KITTITAS COUNTY

MEMORANDUM

TO: All Staff
FROM: Public Works Plan Review Team
DATE: August 26, 2022
SUBJECT: BL-22-00017 Rosenberry

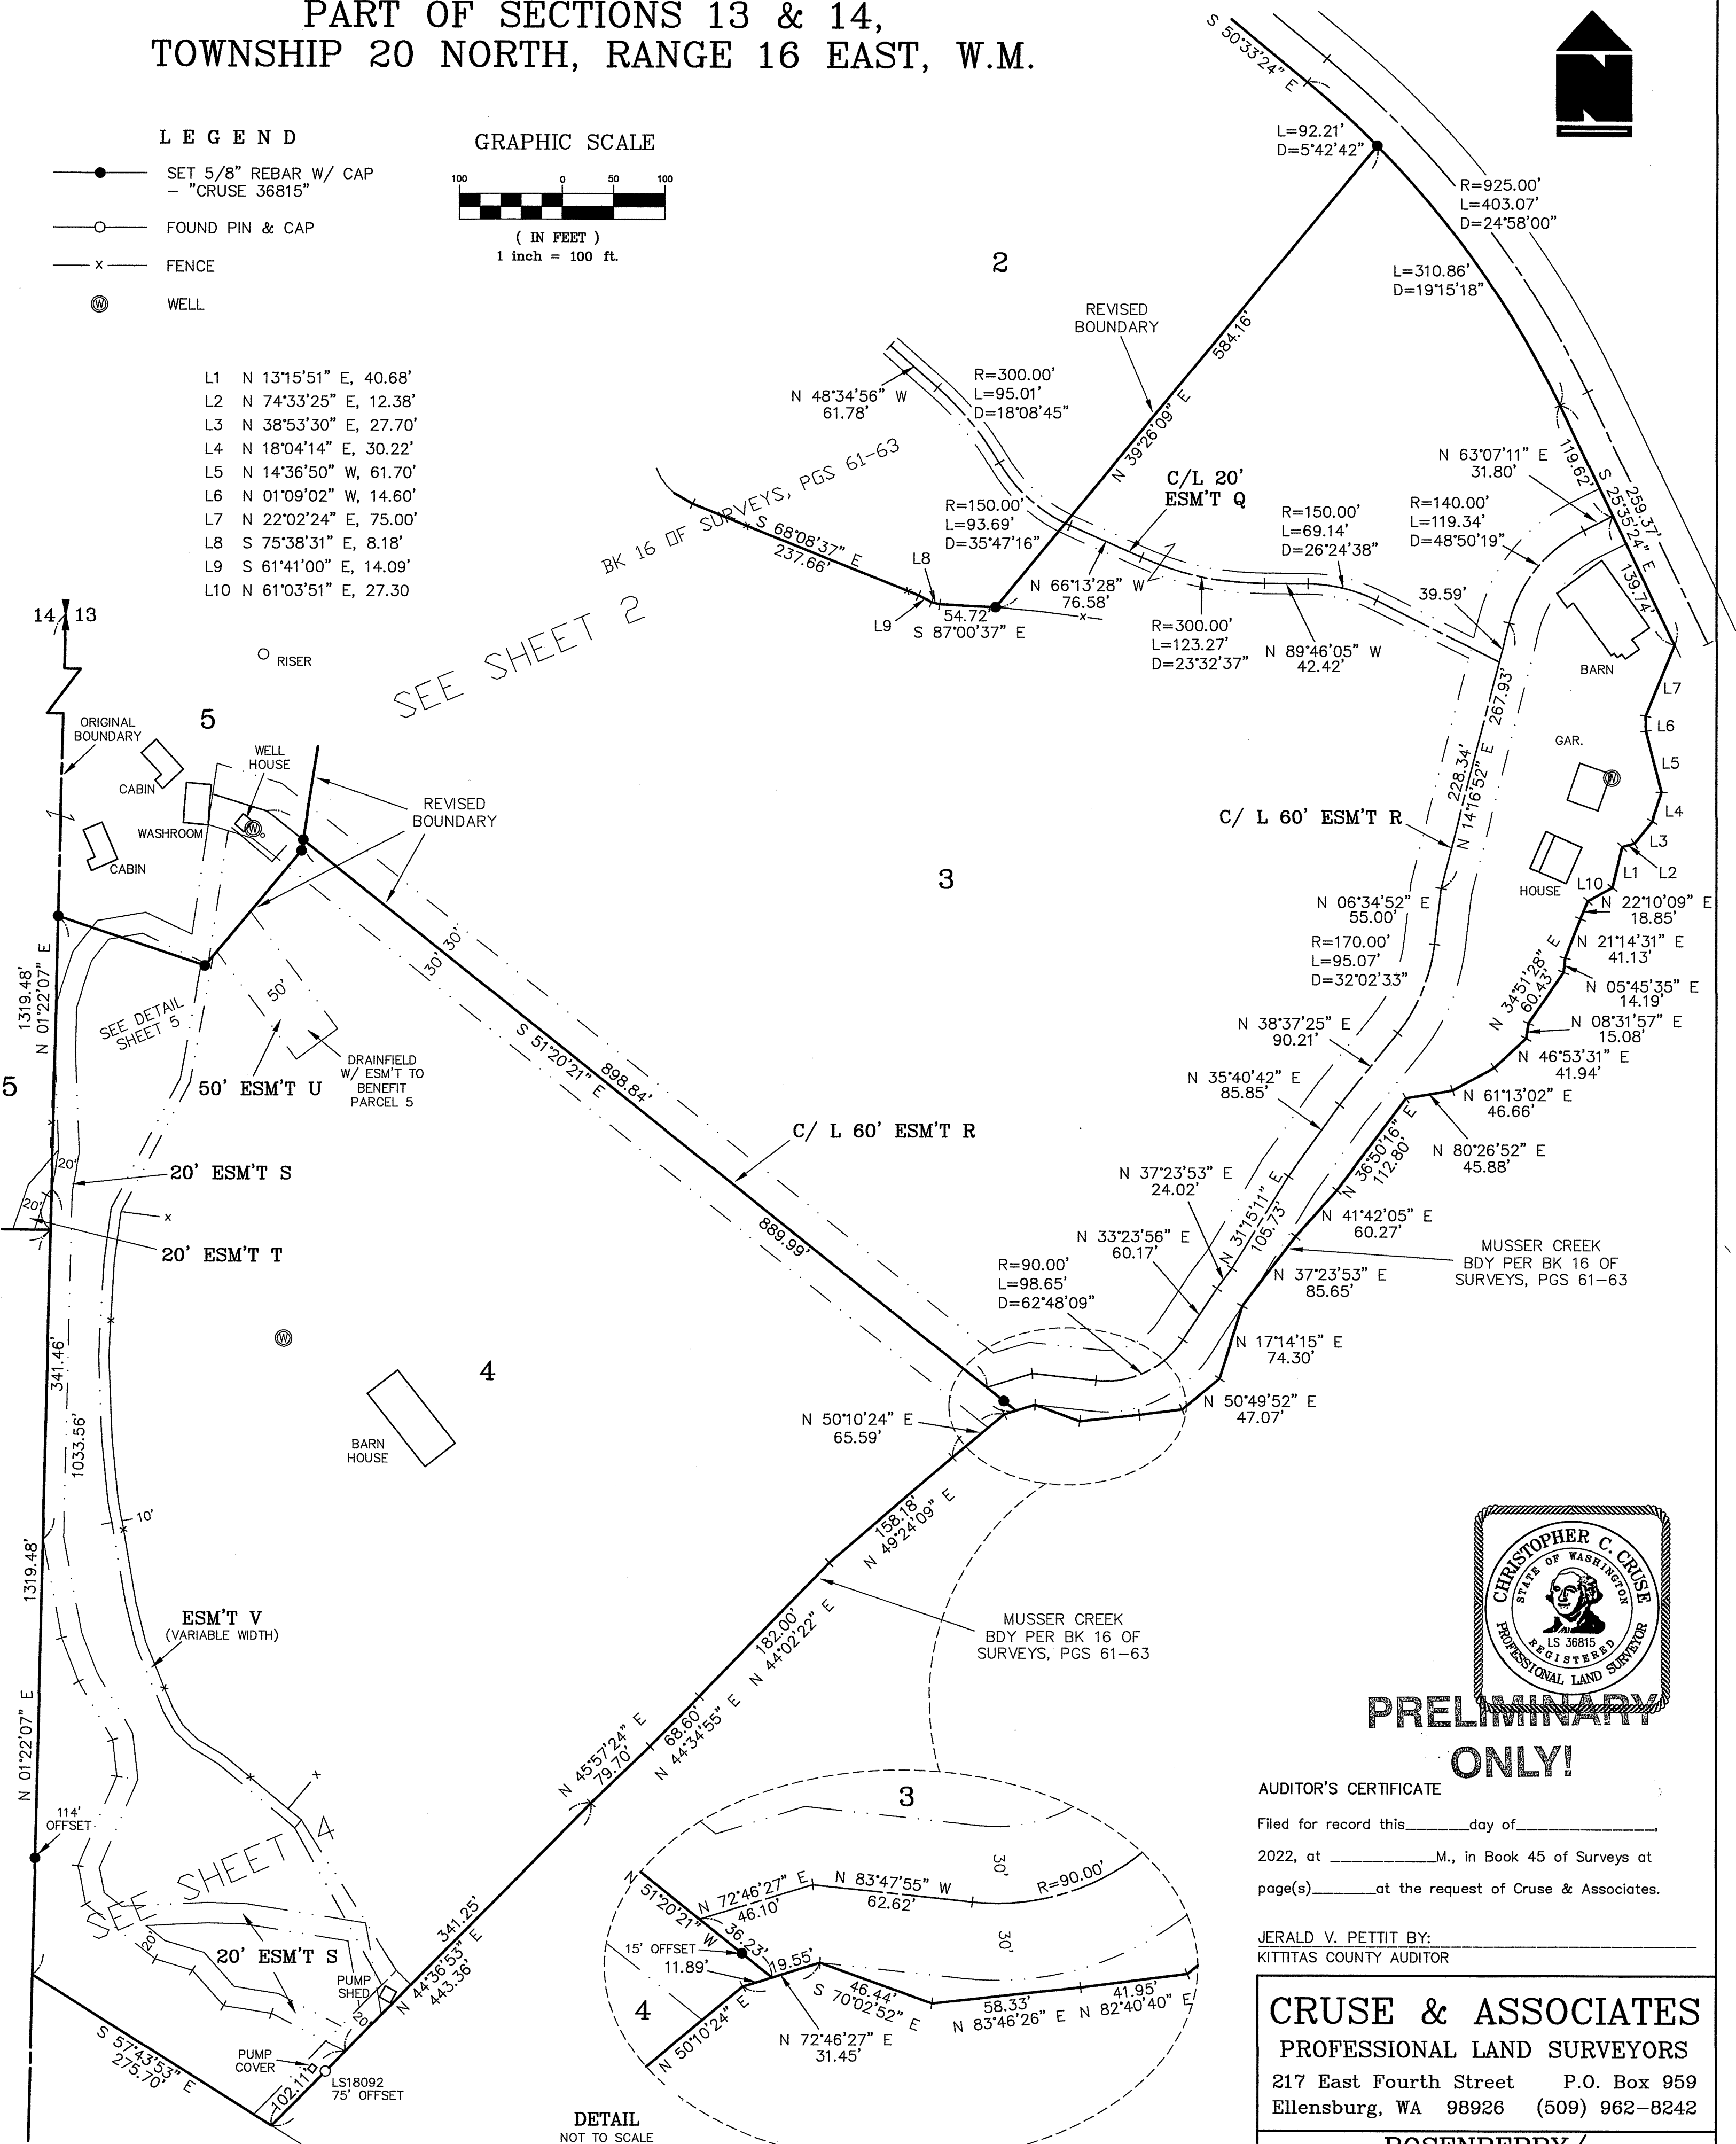
FLOOD	Portions of proposed parcels 1 and 4 will be located in the 100-year floodplain and floodway. If possible, any future development should remain outside of the floodplain in order to reduce risk and avoid mandatory flood insurance purchase requirements. The floodway is highly restricted, and any development must demonstrate no rise in the level of the 100-year flood before being permitted. No new or substantially improved residences are allowed within the floodway. All activities within the floodplain must be permitted through the floodplain development permit process and follow the regulations within KCC 14.08. While not required by KCC 14.08.220, it is suggested that the floodplain and floodway boundaries are outlined on the face of the recorded survey.
WATER MITIGATION/ METERING	No comments
